From: Amanda Scholes on behalf of Planning.Responses
Sent: 01 June 2020 11:59
To: Planning Scanning
Subject: FW: *EXTERNAL: RE: BN/18/20/PL, Former Brooks Nursery

From: Paul Cann <Paul.Cann@arun.gov.uk>
Sent: 01 June 2020 09:38
To: Webster, Gary <[REDACTED]>; Maria Tomalova <Maria.Tomalova@arun.gov.uk>
Cc: Gateley, Jon <[REDACTED]>; Jones, Julian D <[REDACTED]>
Subject: RE: *EXTERNAL: RE: BN/18/20/PL, Former Brooks Nursery

In terms of the proposals effect on the existing suds (surface water drainage system), I would like to make the following comments;

Section 104 Layout Phase 1

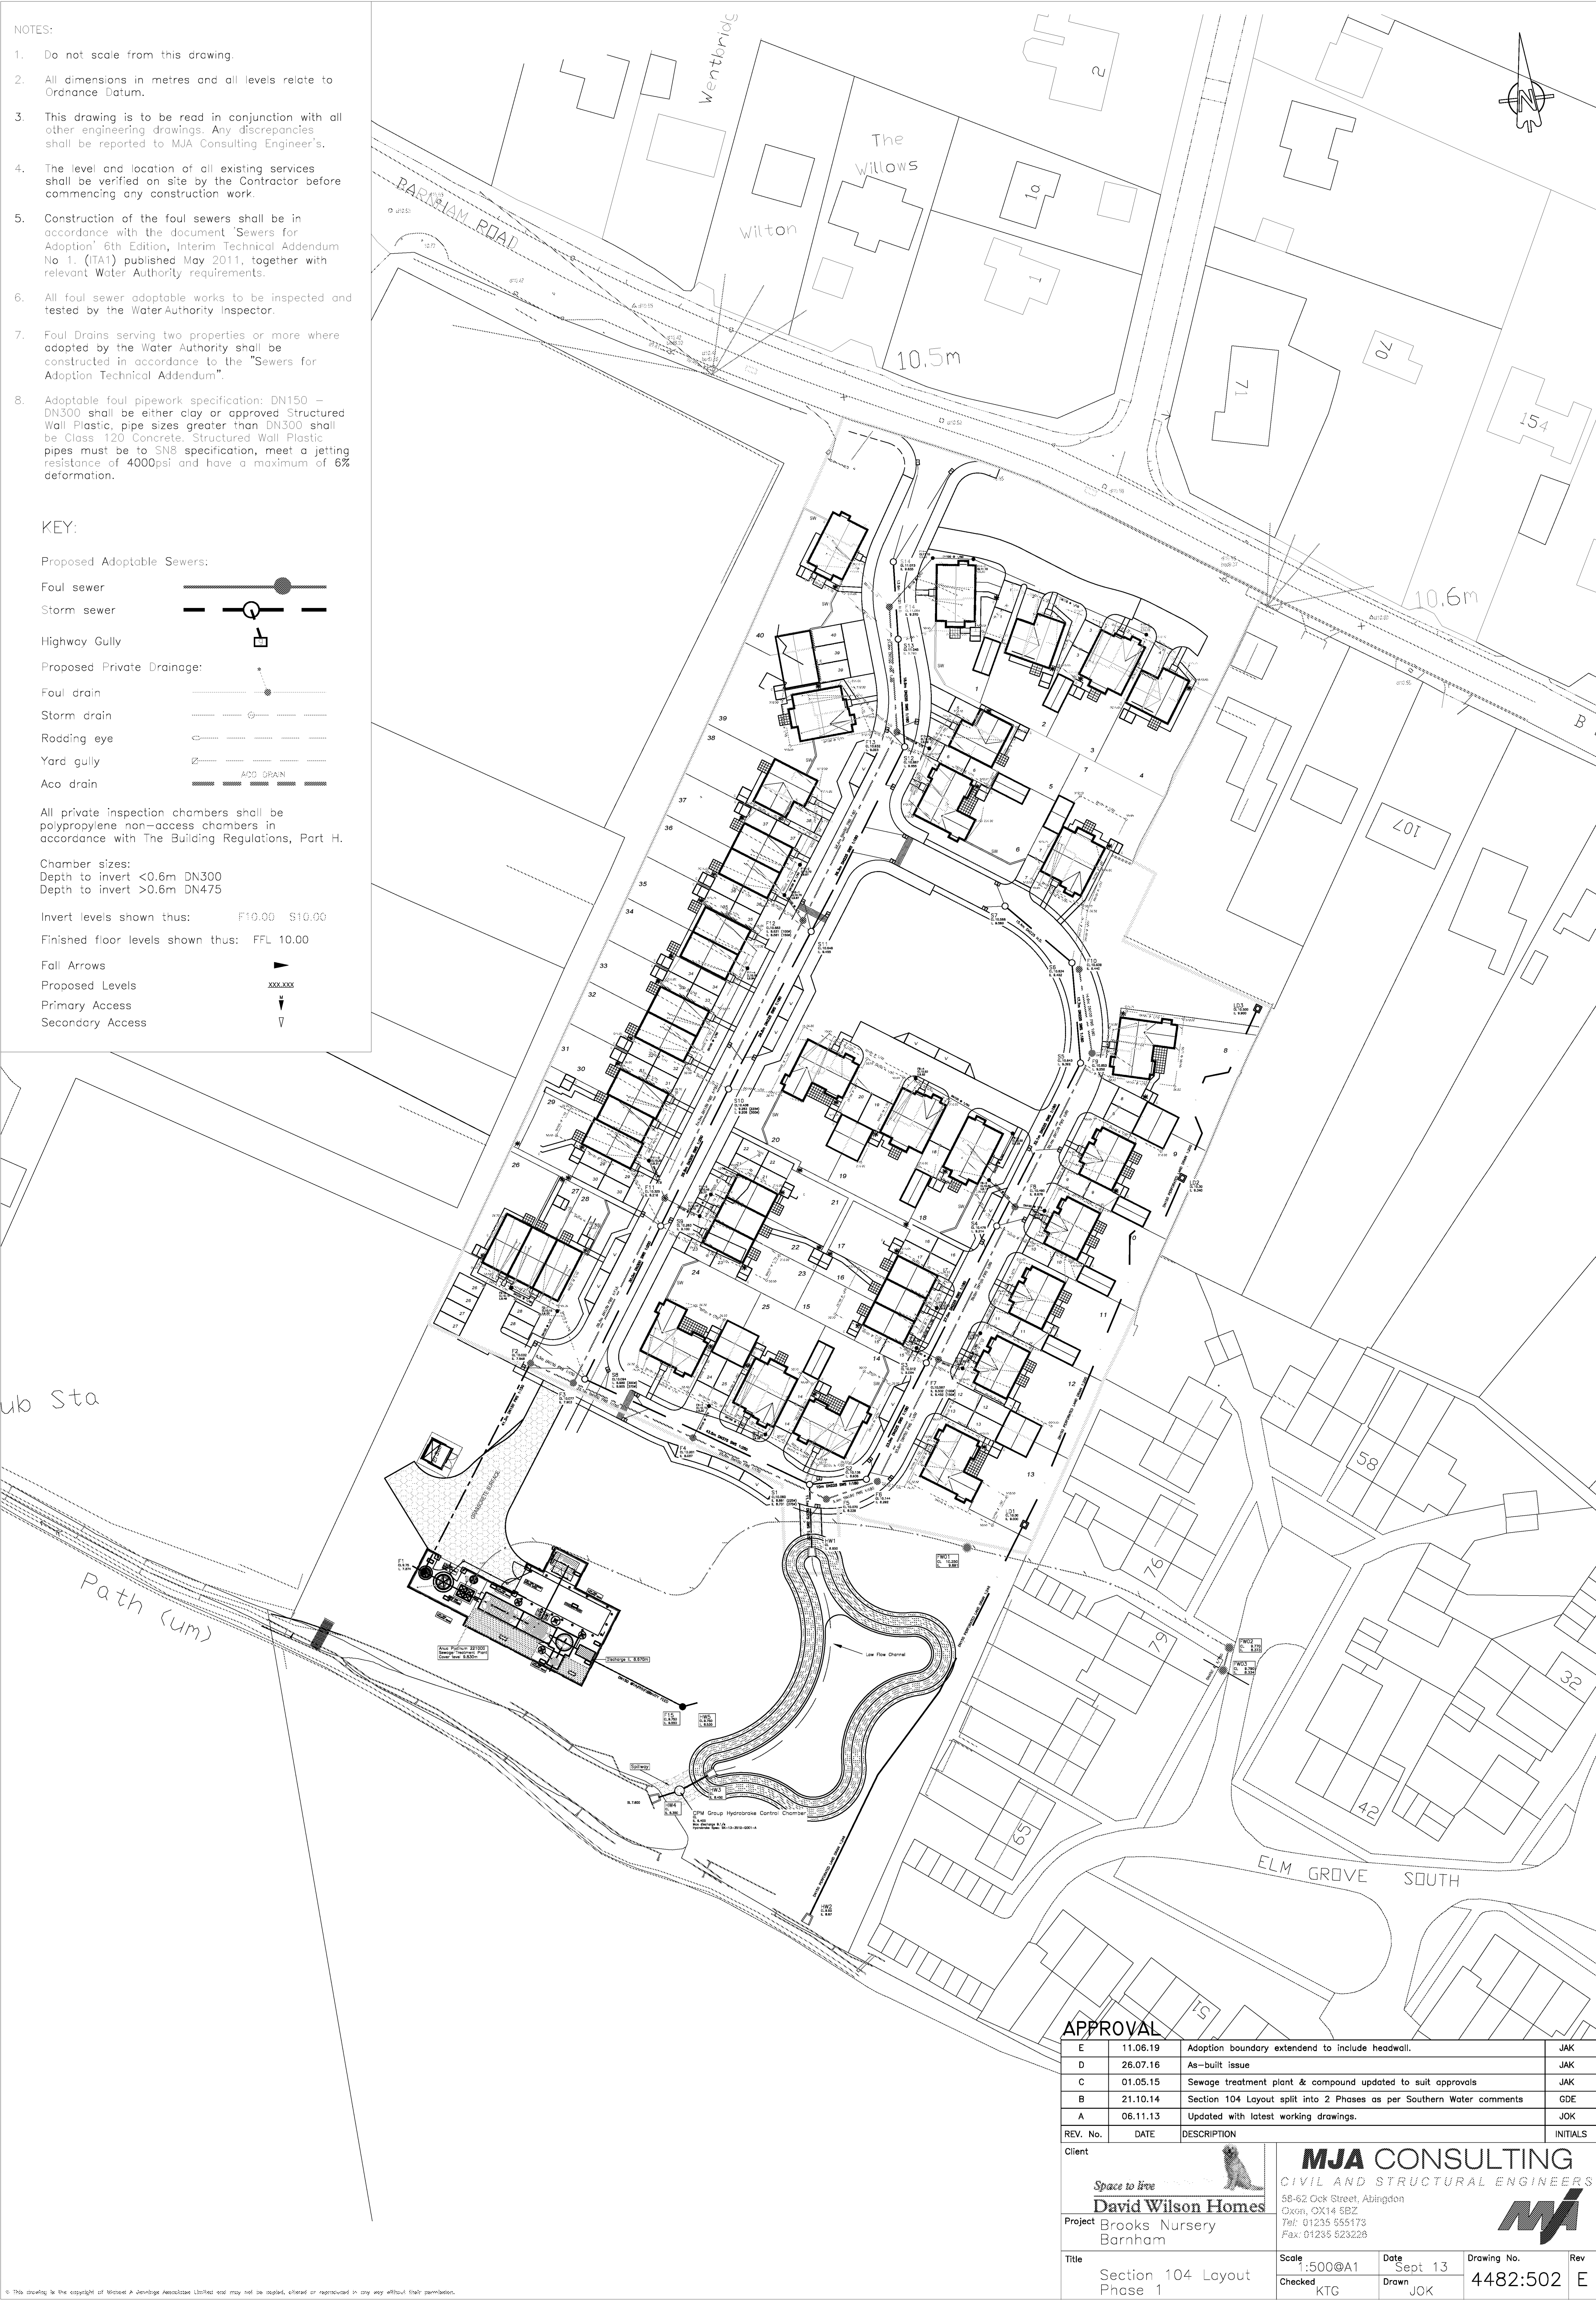
Just for clarity, is the effluent ditch to be retained or infilled. Your email suggests it will remain but the drawings show it to be filled. I have no objection either way.

- a) The open channel/ditch in which the sewage treatment plant discharges into at present, before it connects into the suds pond, is proposed to be infilled.
The applicant will need to be provide written confirmation with supporting calculations to prove that the storage for surface water within the suds system is not compromised as a result.
- b) Where the proposed rising crosses the incoming surface water outfall to the pond and the known land drain running parallel to the eastern boundary of the development, the applicant should provide a longitudinal section to prove no impact on these pipelines.

It was suggested to be retained due to ecology + wildlife benefits

A meeting was held with Paul Cann and Rosemarie Dannatt , just before lockdown, and it was agreed to leave the existing ditch and not infill. This was due to ecological & wildlife benefits

The storage calculations for the surface water pond were also not required to be updated, as its current capacity allows for foul water storage too, which will be no longer required. We were simply asked to bund off the redundant incoming swale.
